Planning Application Ref: AL/107/16/RES

Location: Land west of Westergate Street & east of Hook Lane, Westergate

Description of works: Application for Reserved Matters following Outline Approval being granted at Appeal.

Bernie Harverson - Consultant Arboriculturist

BDWS20440-03

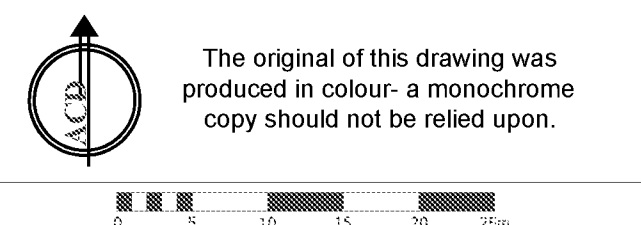
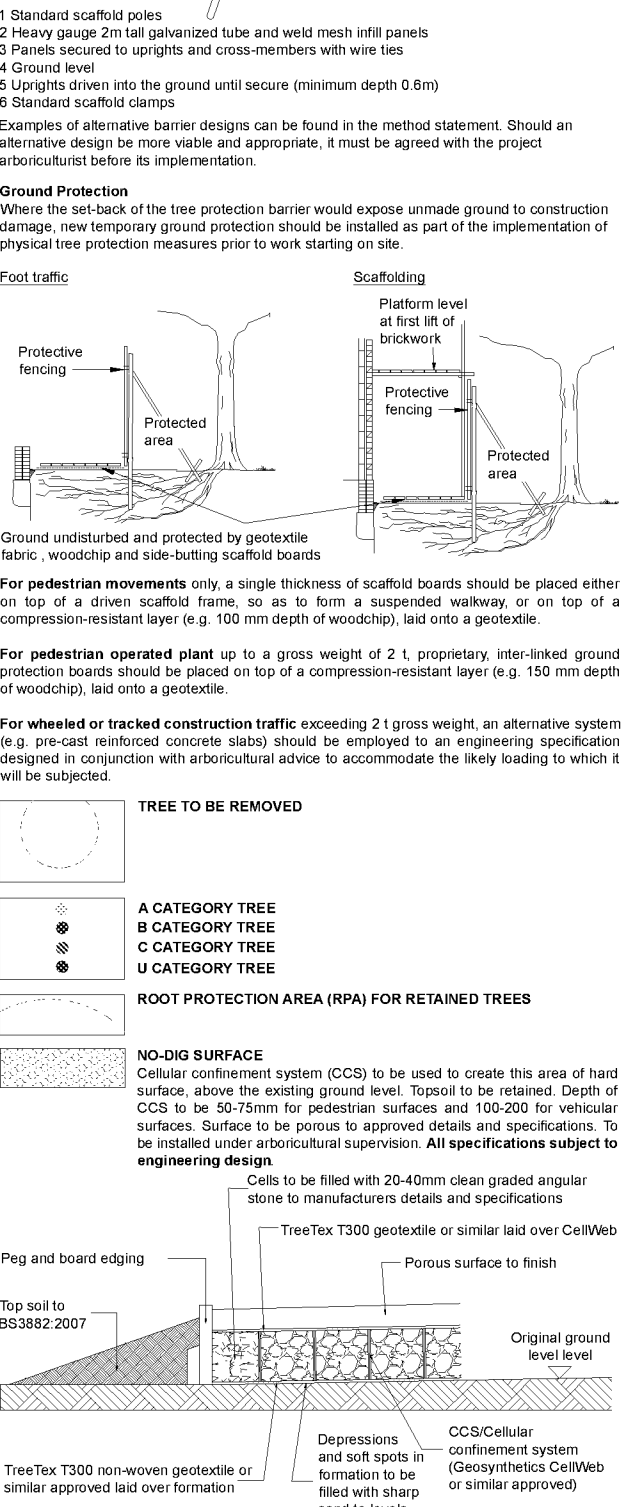
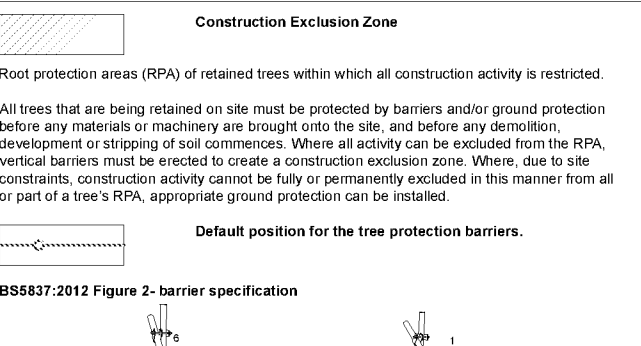
- a) they are specifying ground protection beneath trees 4, 5 & 6 and 'No Dig' Cellweb surfacing detail for the access road and footpath which is fine but the 'No Dig' Cellweb needs to be shown to come all the way westwards up to the building line of Oakdene.

- b) there will need to be Arb. Expert monitored 'hand digging' of slit trenches to the south of Trees 1 & 4 and 5 at the back edge of the new footpath to sever roots of 25mm diameter and under with bypass secateurs.

- d) There is a contradiction in that whilst we are having 'No Dig' surfacing laid to the south of trees 4,5 & 6 they then specify that all utility service trenches will go straight through this zone – this is a 'NO Dig' zone that goes very close to the trunk of and directly through the RPA of the best tree on the site **T6 which is an A graded tree** and would be severely undermined and compromised if these excavation works are approved – I would want to see an alternative offered of 'Thrust Boring' through the RPA of this tree under the main root system at a depth of minimum 1m below the surface.
